From: Speakman, Glenn - Oxfordshire County Council
<Glenn.Speakman@Oxfordshire.gov.uk>
Sent: 17 February 2022 11:09
To: John Cosgrove; DC Support
Cc: Planning Consultations - E&E
Subject: 21/02376/DISC E P Barrus Ltd, Launton Road, Bicester, OX26 4UR

Application no: 21/02376/DISC

Location: E P Barrus Ltd, Launton Road, Bicester, OX26 4UR

Transport Development Control

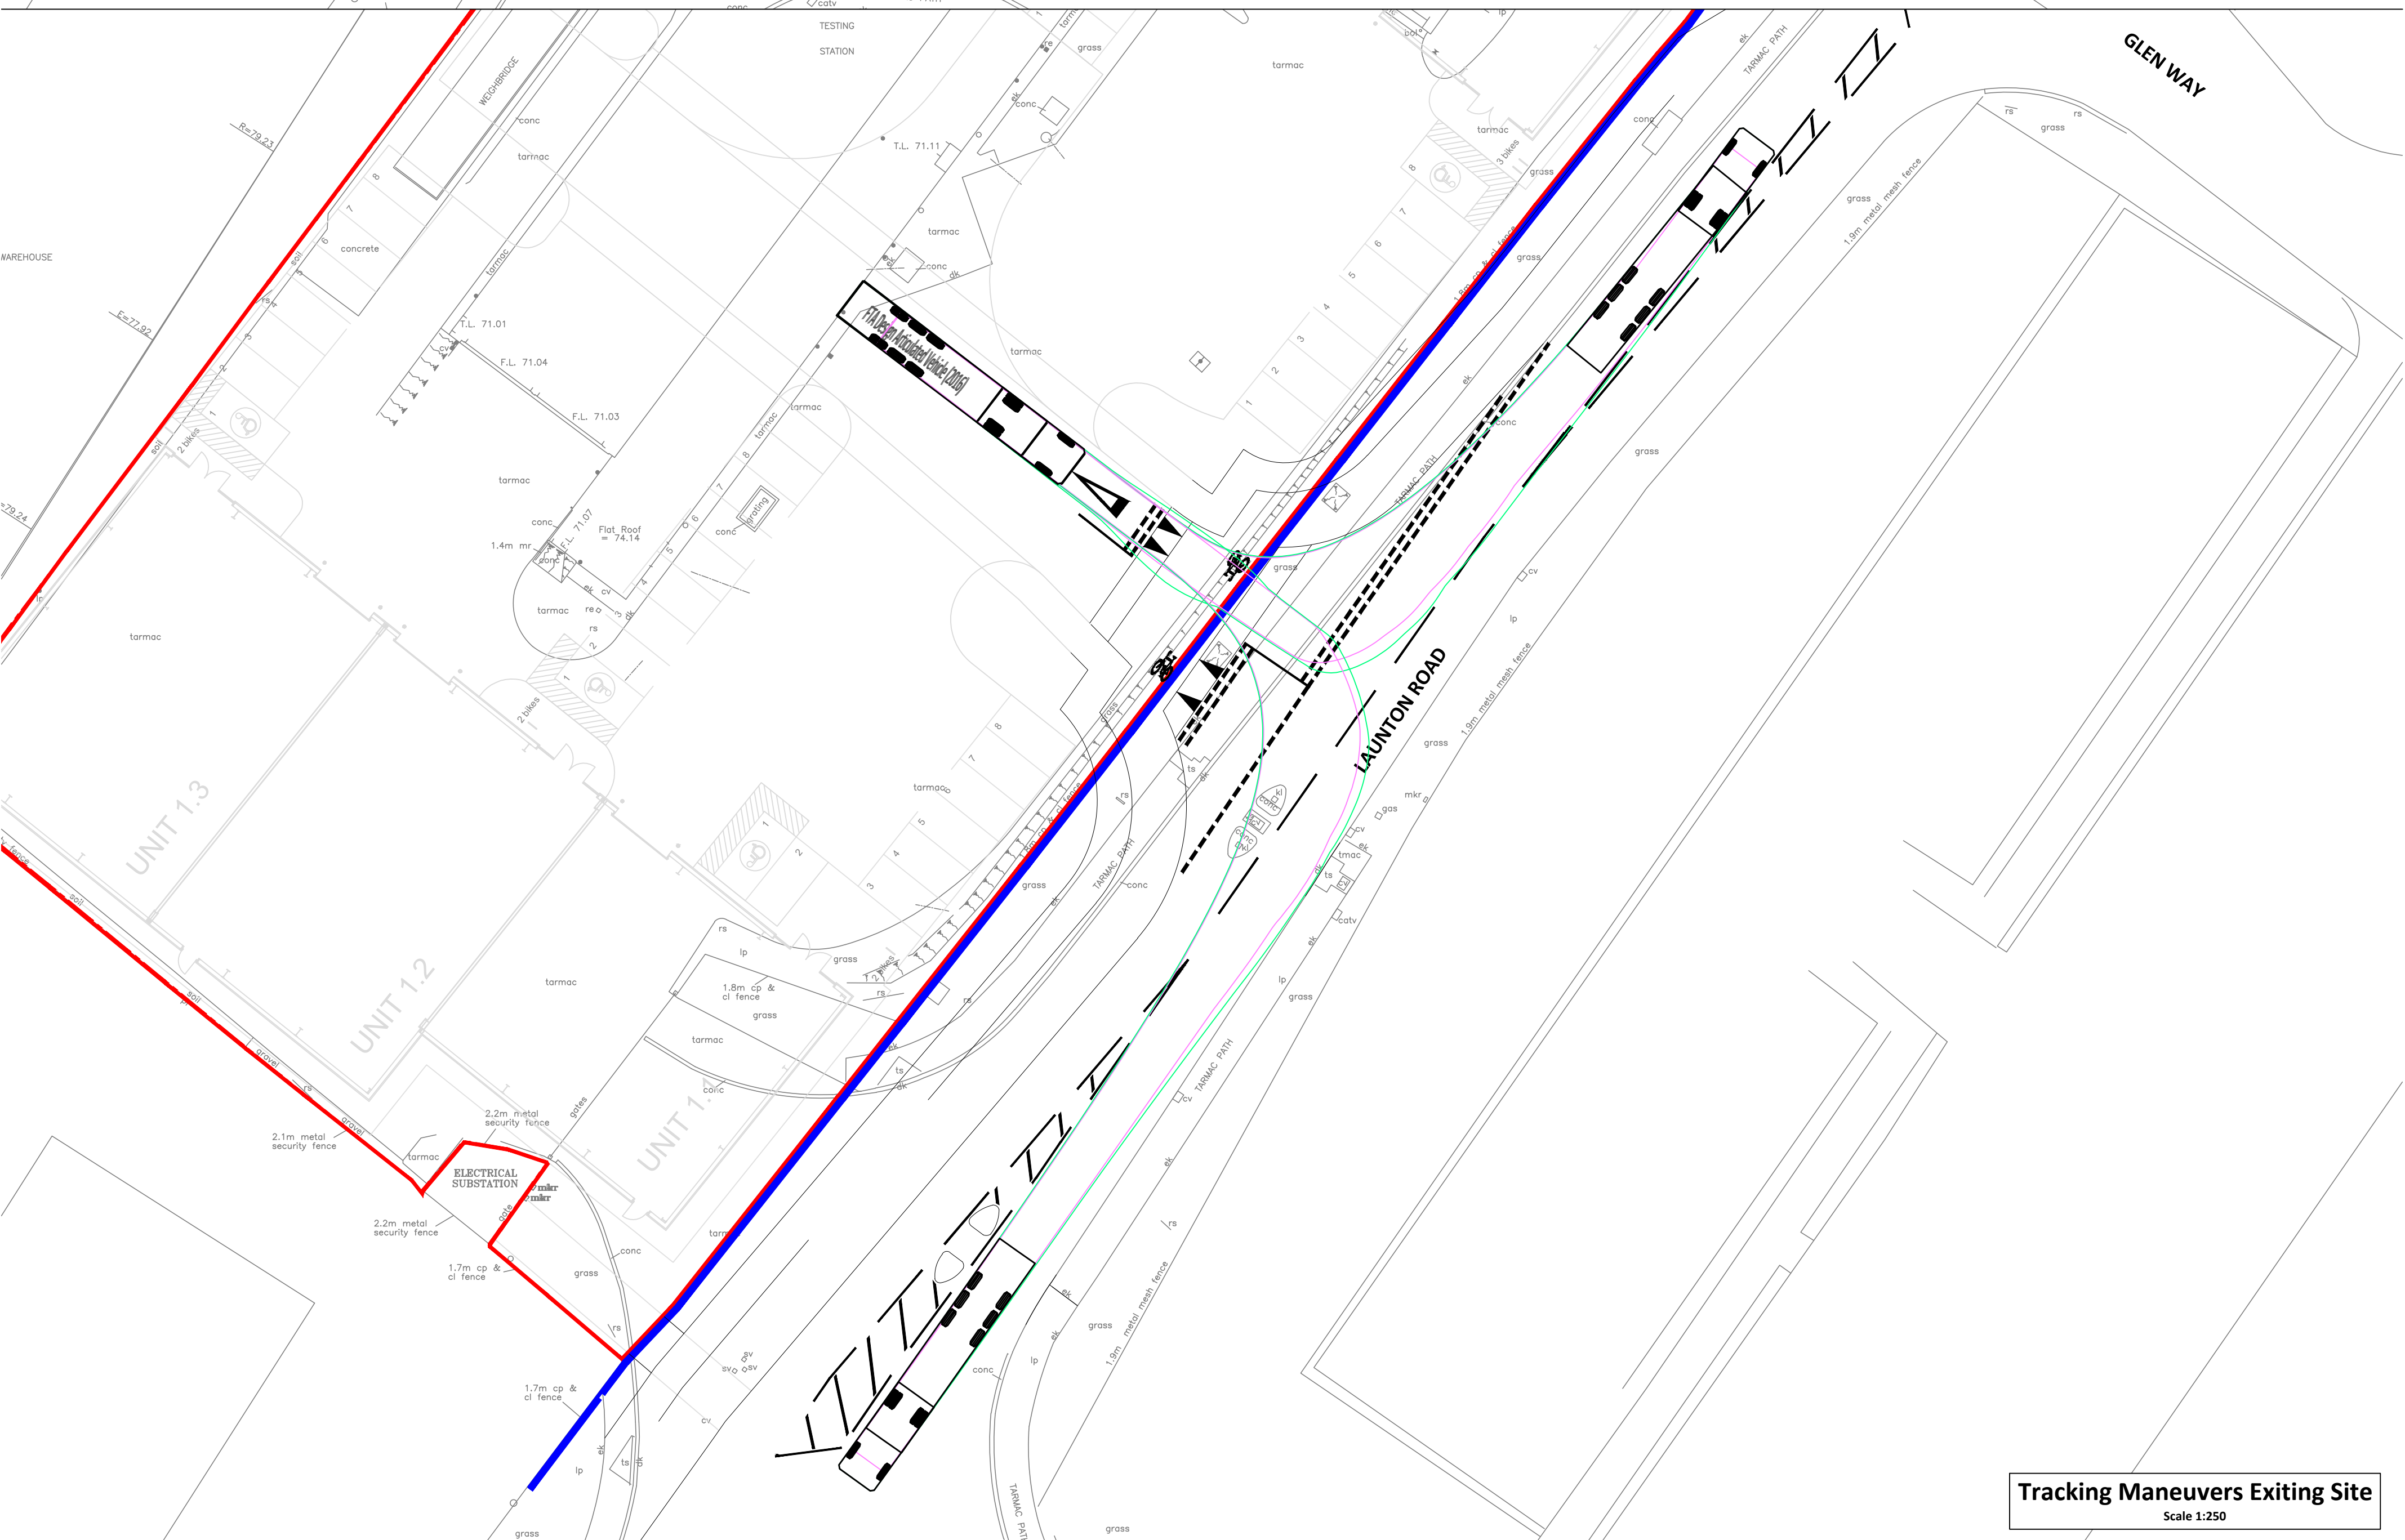
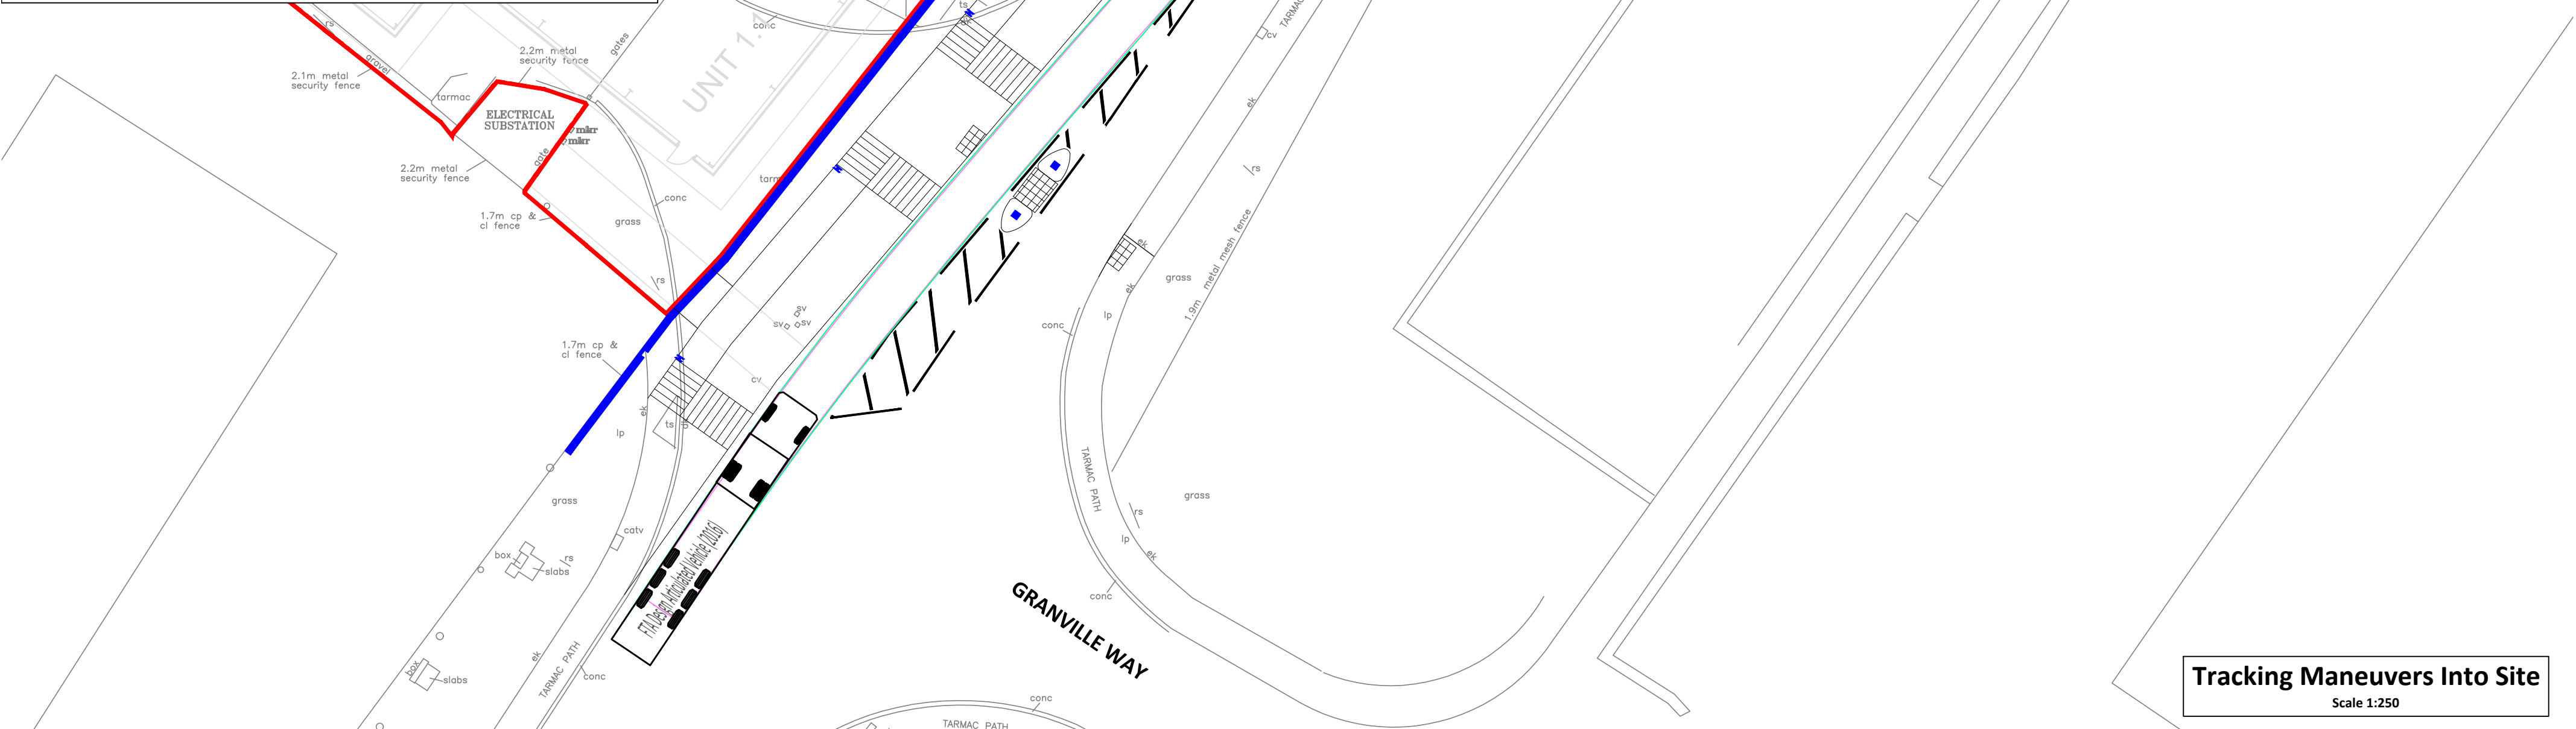
Condition 5 - The submitted tracking diagrams show an articulated vehicle safely entering and exiting the site.
